Wilpshire Parish Council would like to comment as follows:

3/2017/0275 8 Lyndale Close Wilpshire

The application is for a single storey kitchen and living room extension in the rear garden of dwelling.

proposed part ground floor plan.

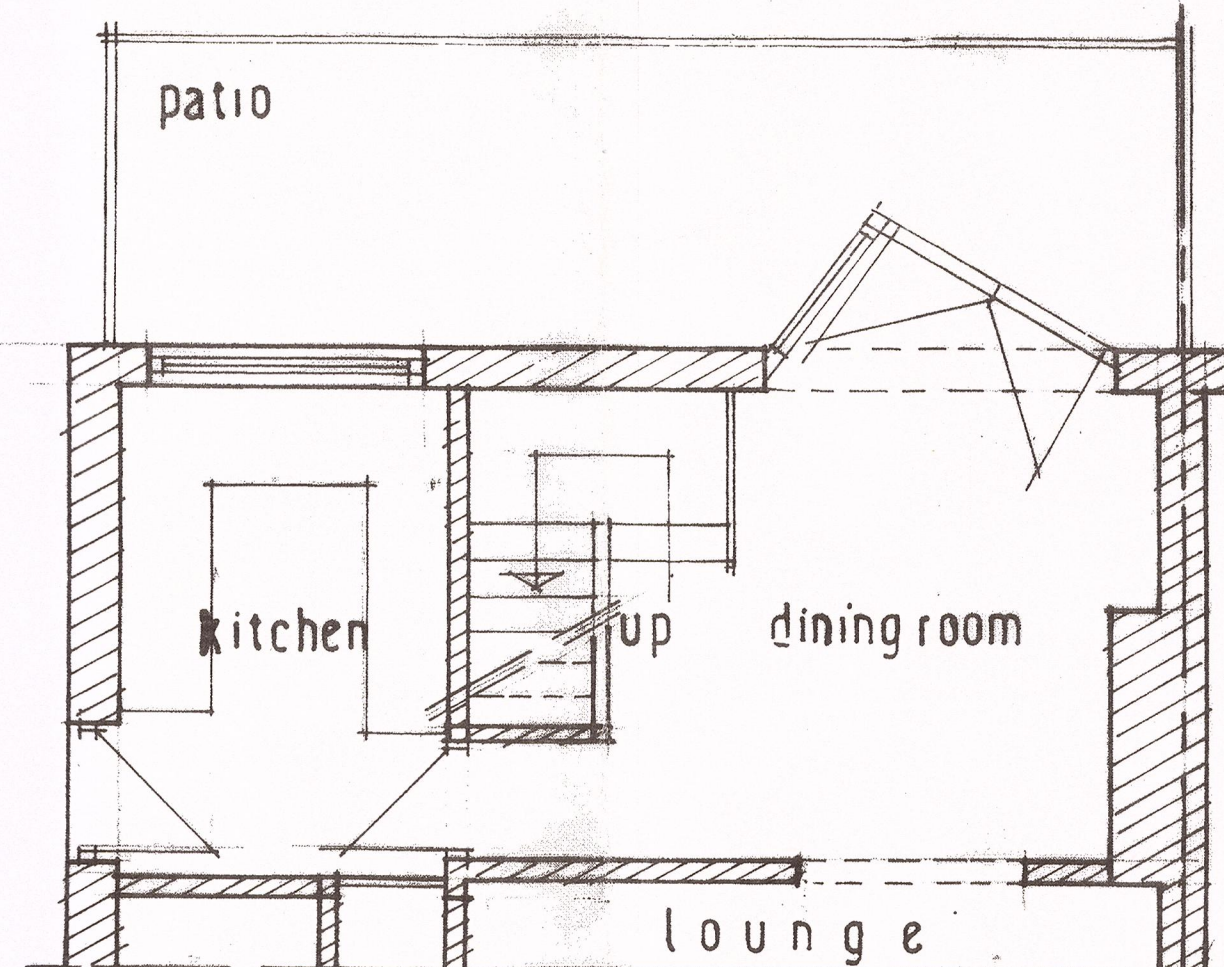
WPC – Object in regards to the patio/decking area which may impact the amenity of the adjacent property.
